From: Laura Gibbons
Sent: 02 November 2021 14:09
To: Maria Tomalova
Subject: RE: Planning Consultation on: AL/114/21/DOC

As per my previous correspondence on this site I believe it would set an unacceptable precedent to accept a design based on infiltration testing completed outside of winter and ignoring worst case results. I would suggest that infiltration testing needs to be completed this winter at the proposed location for surface water drainage.

Scale	As shown	At original	A3
Drawing Number	2112/SK4	Revision	-

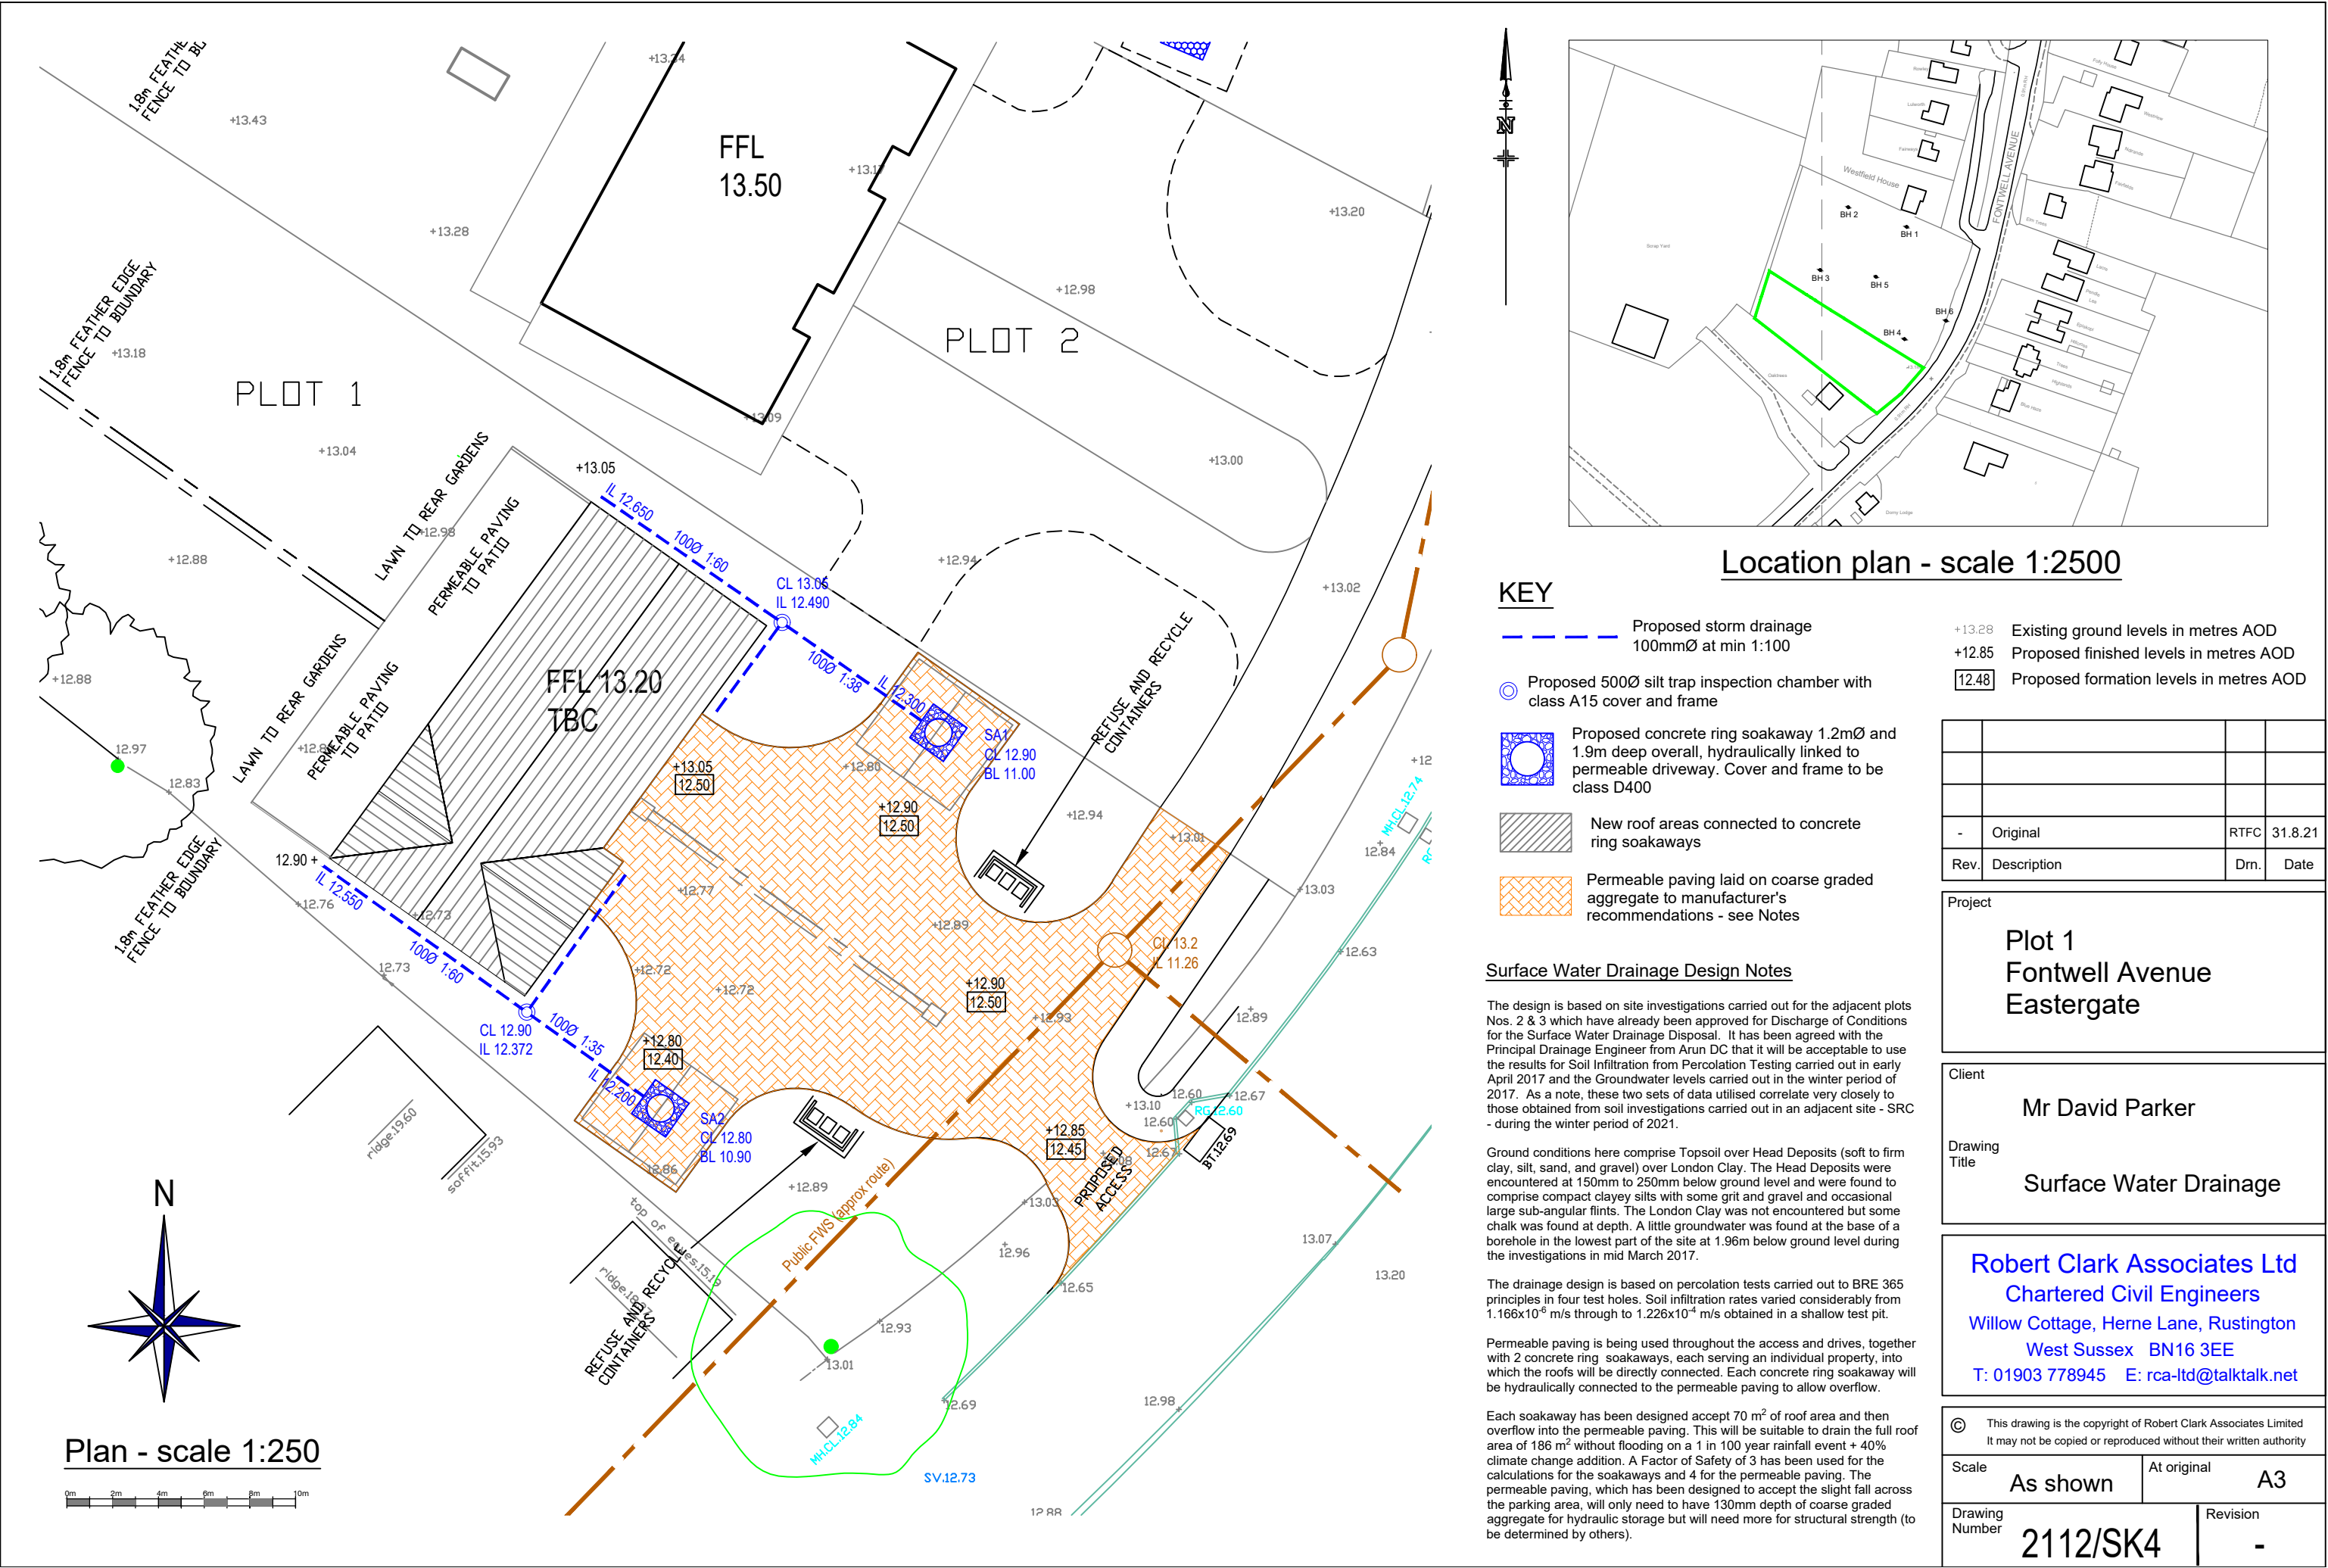
If the applicant is unhappy with this then as a compromise we would accept a design based upon the lowest obtained infiltration rate. It is clear that this value was not an anomalous value as a further testing location also demonstrated rates in the low $\times 10^{-6}$ m/s range.
